PROPOSED NORTHCONNEX M1 / M2 TUNNEL PROJECT - Application Number - SSI 13_6136
We object to many aspects of this project

MOTORWAY OPERATIONS COMPLEX - SOUTHERN VENTILATION FACILITY - SECTIONS
M1-M2-5000-DR-JD-0525

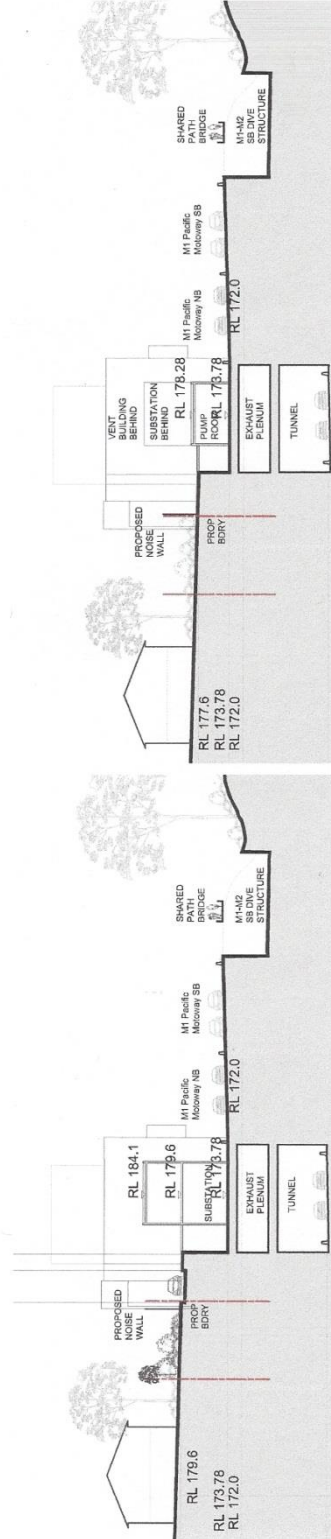
1. The Environmental Impact Statement (EIS) does not show any connection between the ventilation stack and the southbound tunnel which is 250 metres away. Will the polluted air be allowed to flow like an invisible sewer through West Pennant Hills, North Rocks, Carlingford and Beecroft?
ACTION: Provision of diagrams and detailed description of what ventilation is proposed for the southbound tunnel at the Southern Interchange. We would like the opportunity to lodge further submissions once that has been provided.
